From: Amy Myer <Amy.Myer@arun.gov.uk>
Sent: 07 May 2020 20:40
To: Planning.Responses <Planning.Responses@arun.gov.uk>
Cc: Daniel Vick <Daniel.Vick@arun.gov.uk>
Subject: FW: BE/17/20/DOC Site 6 Chichester Road - DRAINAGE COMMENTS FINAL INFO - EOT 15TH MAY

Comments on construction drawings;

BE/17/20/DOC – Condition 3 (Surface Water Drainage) and Condition 10 (Facilities to enable Car Charging of Electric Cars)

TITLE:
ON SITE HIGHWAY WORKS
TRAPPED ROAD GULLY POT DETAIL

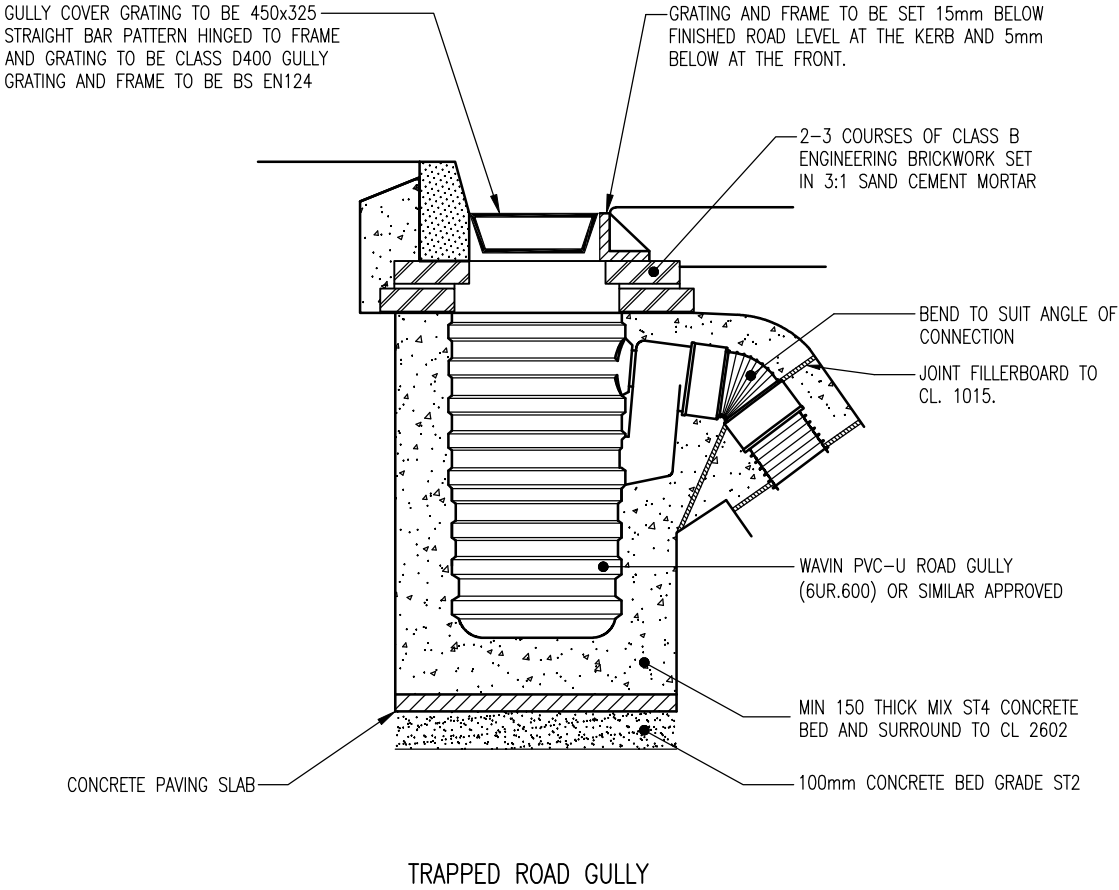
1. Yard gully – specify cover and frame grading.
2. Provide channel drain construction detail (including sump outlet).
